About the application

Application number: 2020/90667	
What is the application for?:	Formation of entrance porch and outdoor terrace, internal refurbishment, replace
Address of the site or building:	Farmers Boy Inn, 44, Marsh Lane, Shepley, Huddersfield, HD8 8AP
Postcode:	EH12 9JZ

client					
STAR PUBS AND BARS					
address					
THE FARMERS BOY 44 Marsh Ln Shepley Huddersfield HD8 8AP					
drawing title					
PROPOSED GROUND FLOOR PLAN					
drawing no	rev	date	drawn by	checked	scale @ A1
7724-02	a	21.05.18	LB		1:50

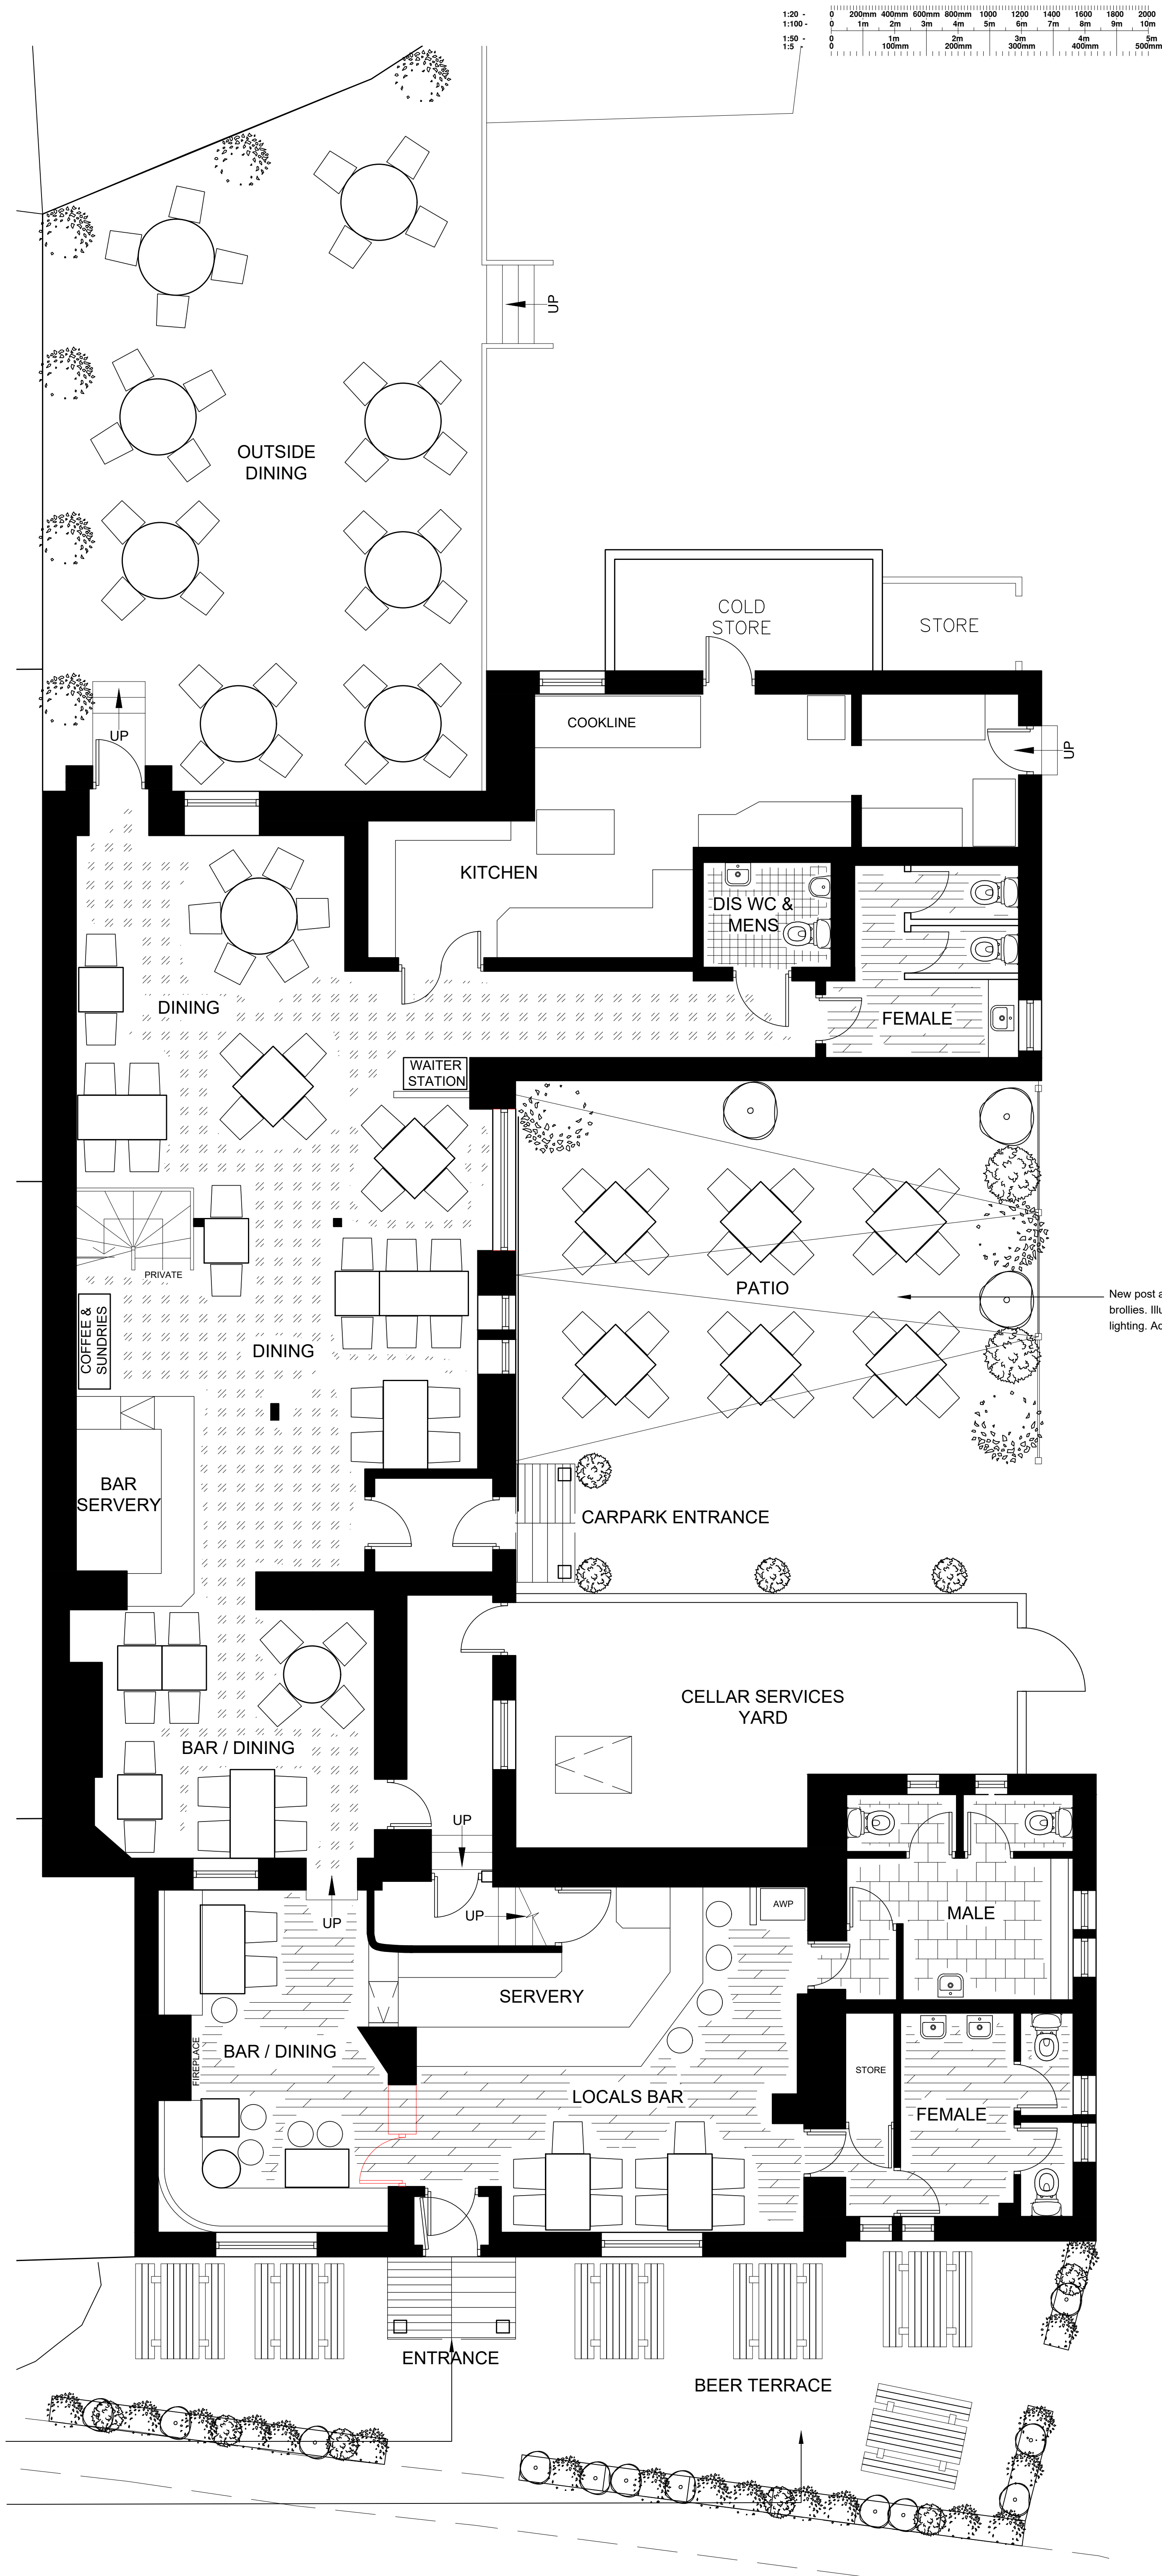
Type of comment: An objection
Whilst I support the reopening of the The Farmer's Boy public house, I have three areas of concern which I would like to see addressed within the planning process: 1. In the planning application there is an increase in the number of restaurant covers yet no details for additional car parking. This will lead to an increase in on street parking which in the narrow confines of Jenkyn Lane could lead to congestion. I would like this issue to be addressed within the application. 2. The proposed increase in external restaurant covers could lead to an increase in noise for the residential neighbourhood that surrounds the public house. I would like the application to assess this issue and detail how it will be mitigated? 3. When the pub was opened in the past there were issues with customers accessing and leaving the pub by climbing over the stone boundary wall on Jenkyn Lane. In fact a stone has been removed from the wall to make it easier to climb. I have regularly seen people jumping down into the road and on one occasion a child jump from the wall into the path of my car to retrieve a ball. I would like to see the application include for open fencing or hedging to block this use? I can see no reasons why these issues cannot be addressed and look forward to Star Pubs and Bars Ltd making a success of The Farmer's Boy.
